Recommendation Report for Planning Permission for Works or Extension to a Dwelling

REF NO: BN/95/20/HH

LOCATION: Larkfield Cottage
Yapton Road
Barnham
PO22 0AY

PROPOSAL: Addition of a dormer to the rear elevation and alteration from pitched roof to gable end with extension to existing drop kerb

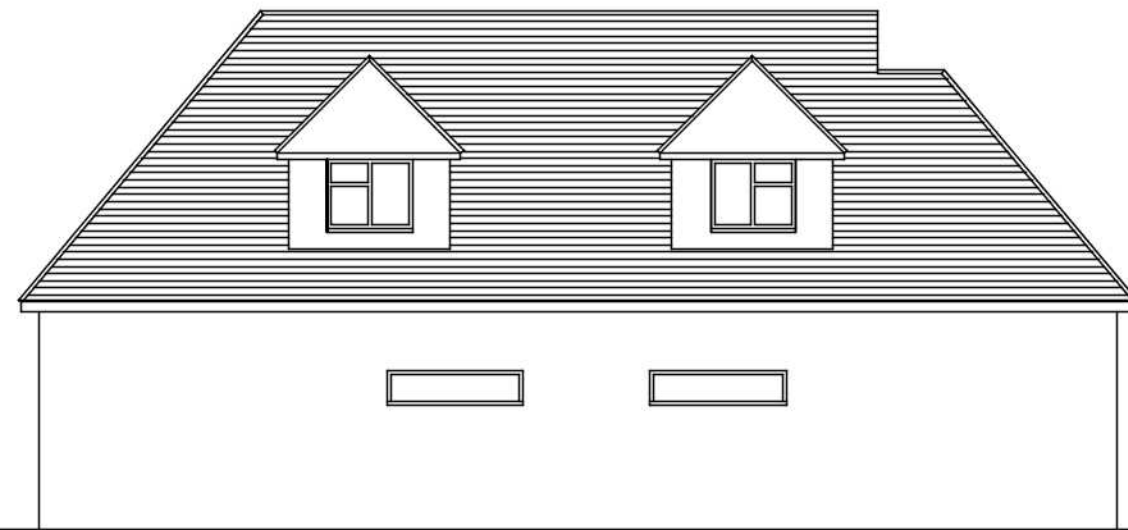
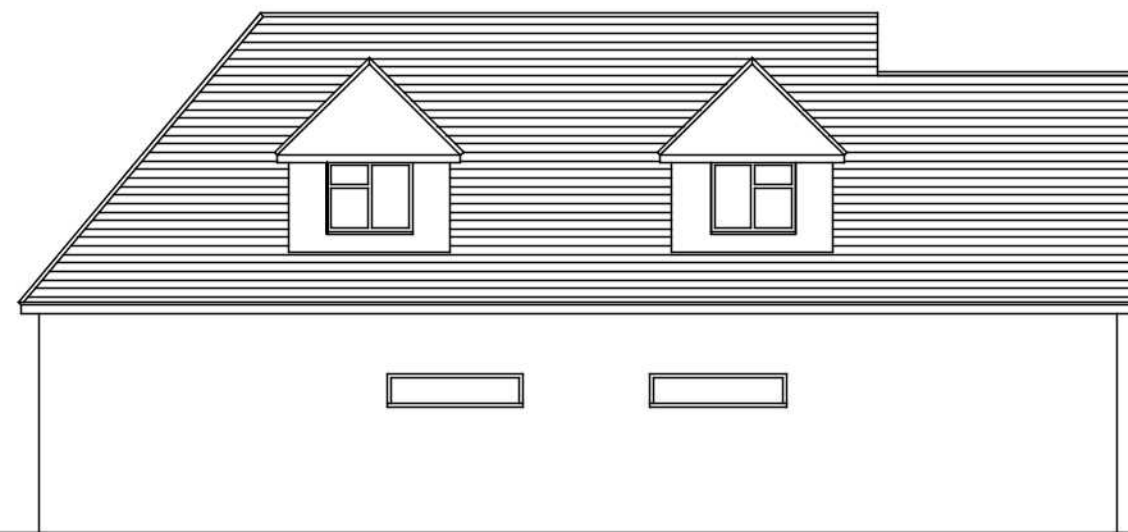
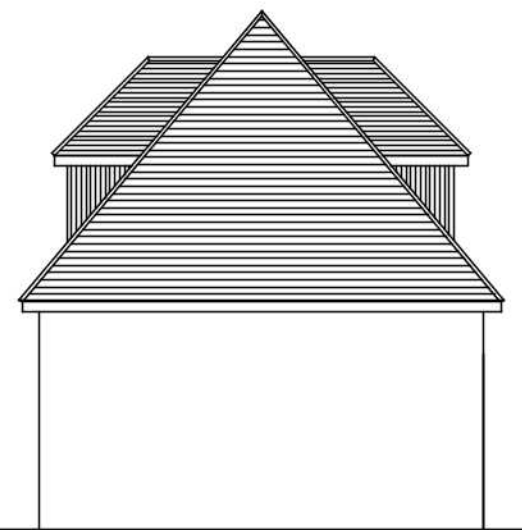
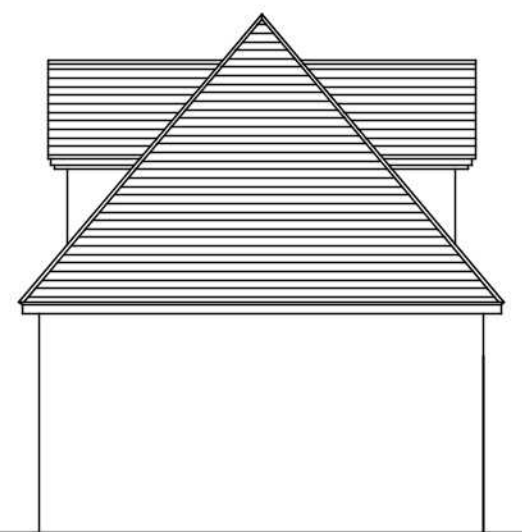
The annexe has an existing side addition with a hipped roof. This will alter to form a gable end with the addition of a small dormer to the front.

The proposal is considered subservient and well integrated. There are existing dormers to the front and rear elevation and the proposed dormer is of a similar design and style and fits comfortably within the roof slope. Materials will also match existing.

The roof to the existing side addition will alter from a hip end to form a gable end. The height and width will remain as existing, although the alteration will add additional bulk to the side addition.

There will also be an additional dormer located to the western elevation. The dormer will have a depth and height of 2.3m and width of 1.8m.

The dormer will look towards the east which fronts the side elevation of the host dwelling and driveway. Due to the siting, it is not considered to give rise to adverse overlooking upon neighbouring amenity, with 2 other dormers also located to this elevation.
